Date: 13 April 2012
Our ref: 50185
Your ref: 3/2012/0090

Proposals for the temporary use of the area of grassland as a remote compound and material store area in relation to a maintenance project to the water on the rivers Brennand and Whitendale

Land off private access track off Newton Road Dunsop Bridge Lancashire

0578/80020061/00/97/1002

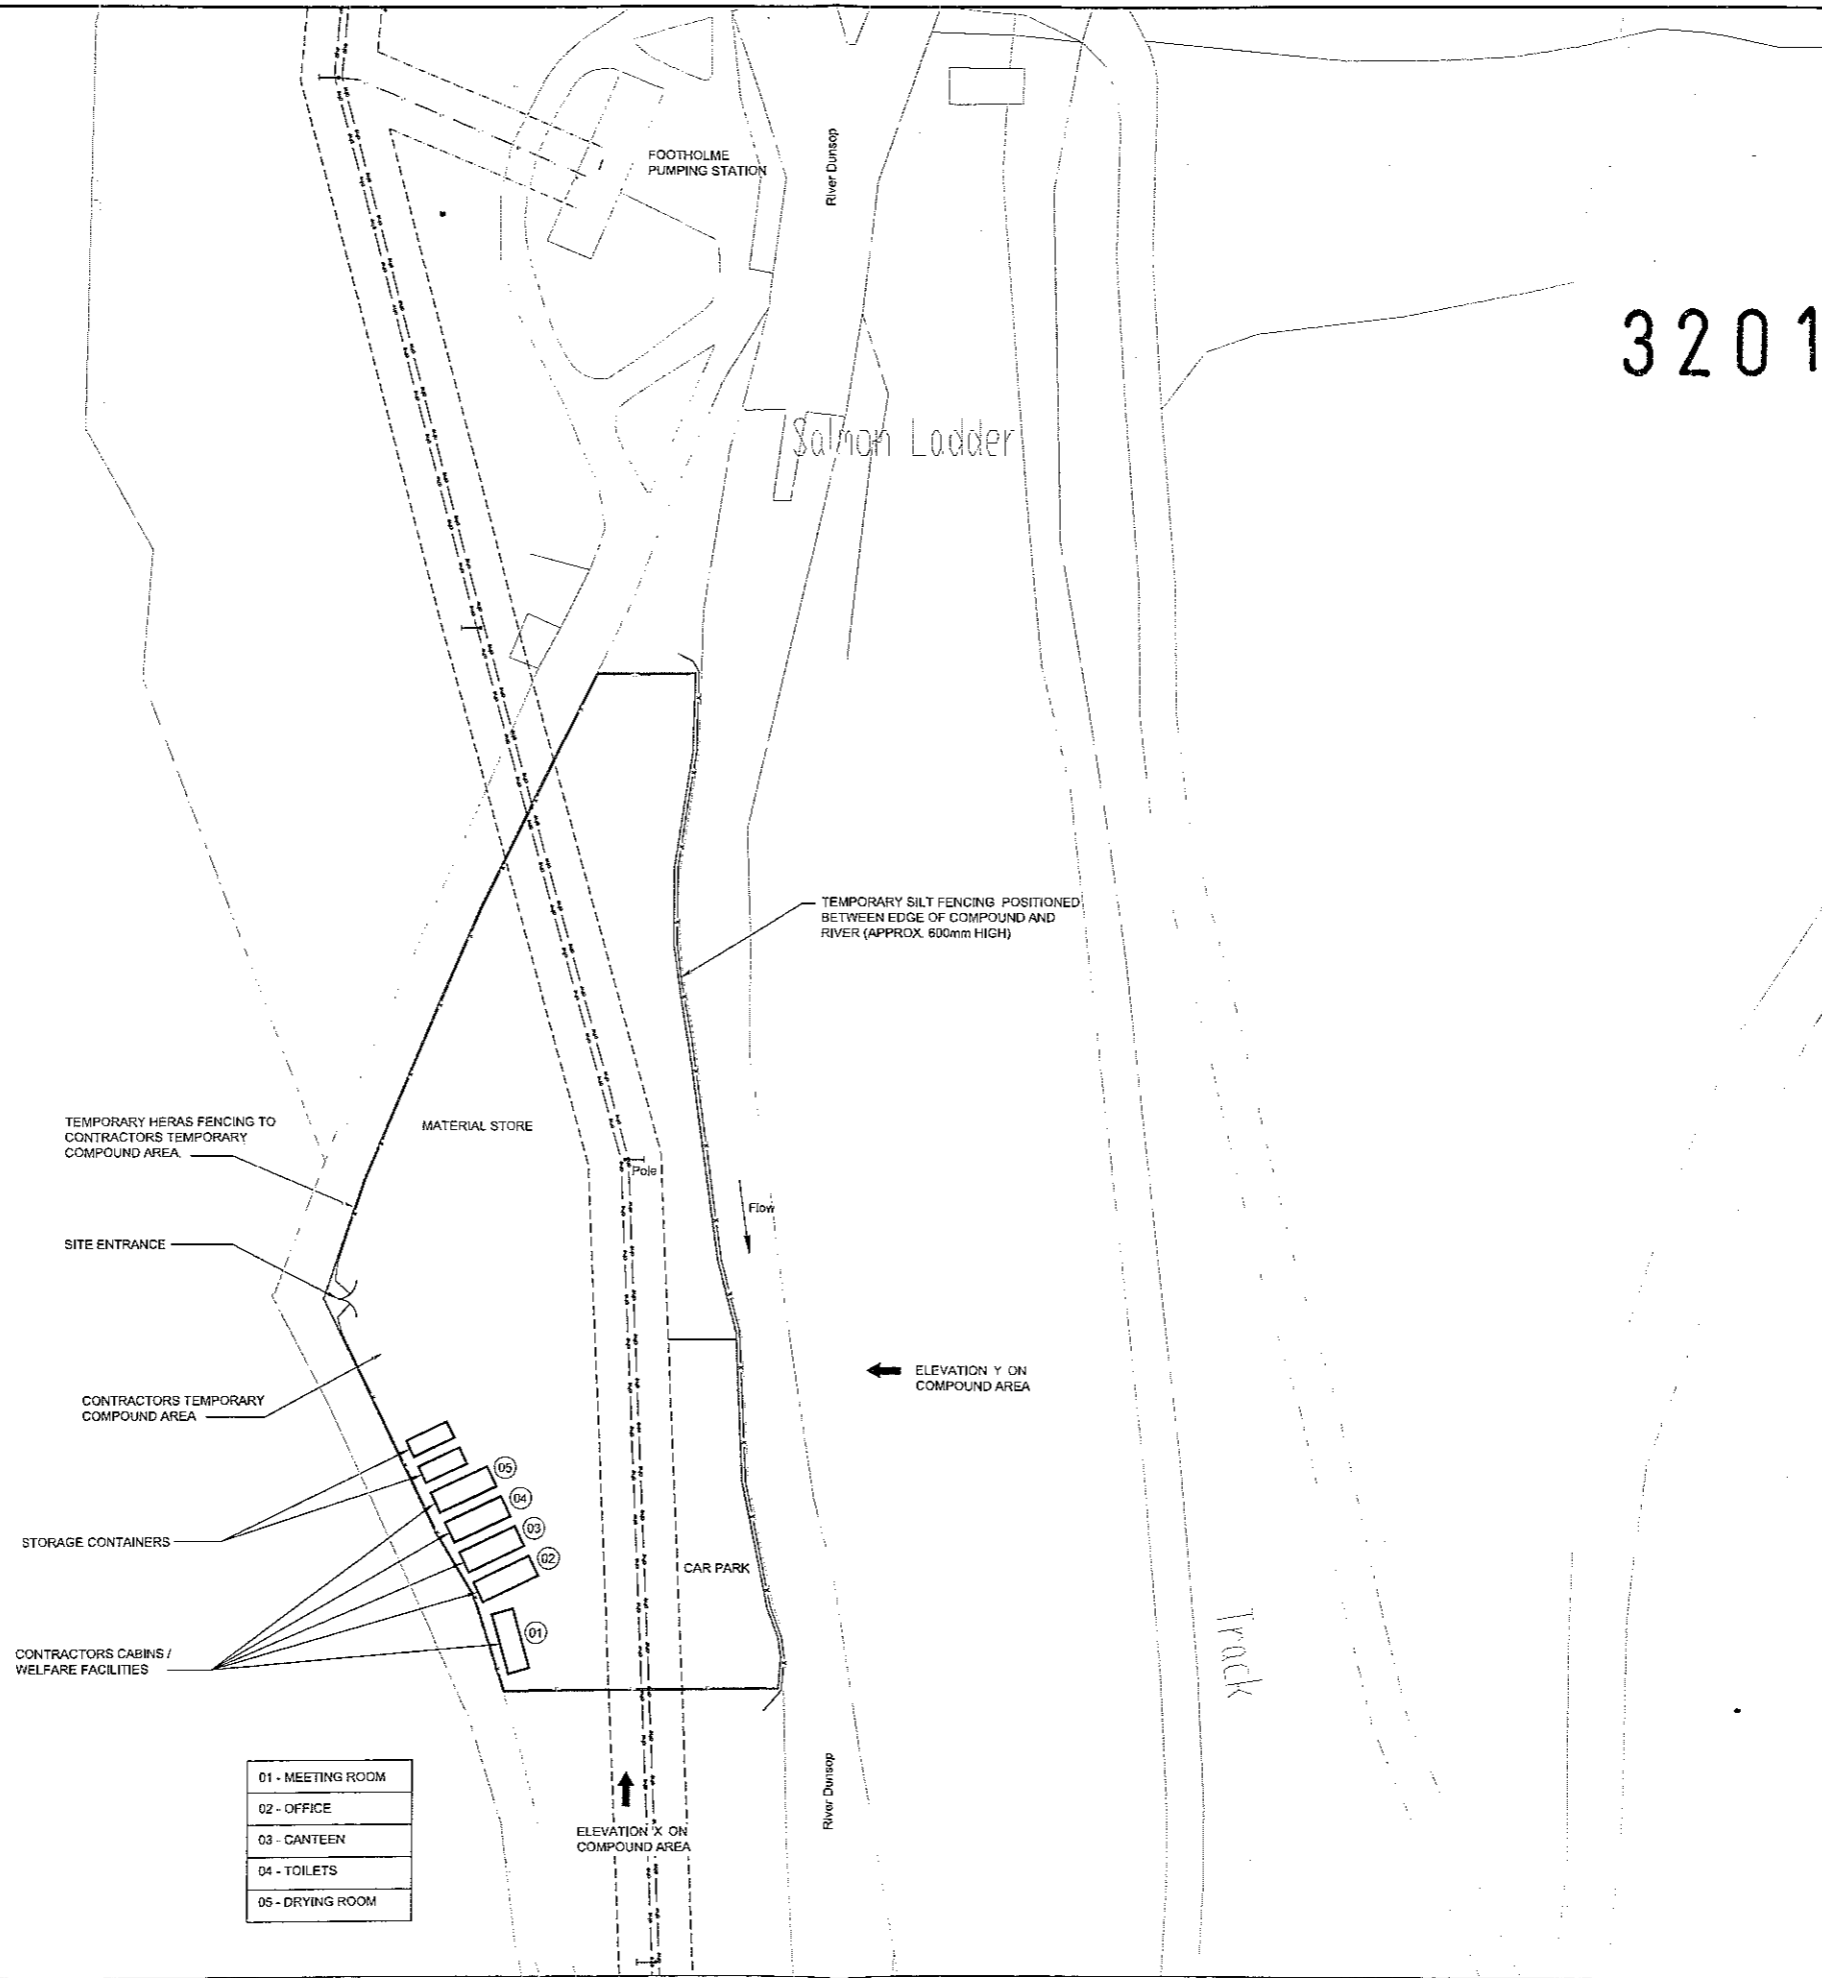
To ensure that there is no direct damage to the habitat of the protected site, a condition should be placed on any permission granted to ensure that vehicles are prevented from damaging the part of the SSSI which lies directly to the east of the track. If there is not already a boundary fence or wall dividing the SSSI from the track, then temporary fencing or marking of the edge of the SSSI should be undertaken, and it should be ensured that no vehicles pull on to the SSSI when passing other vehicles.
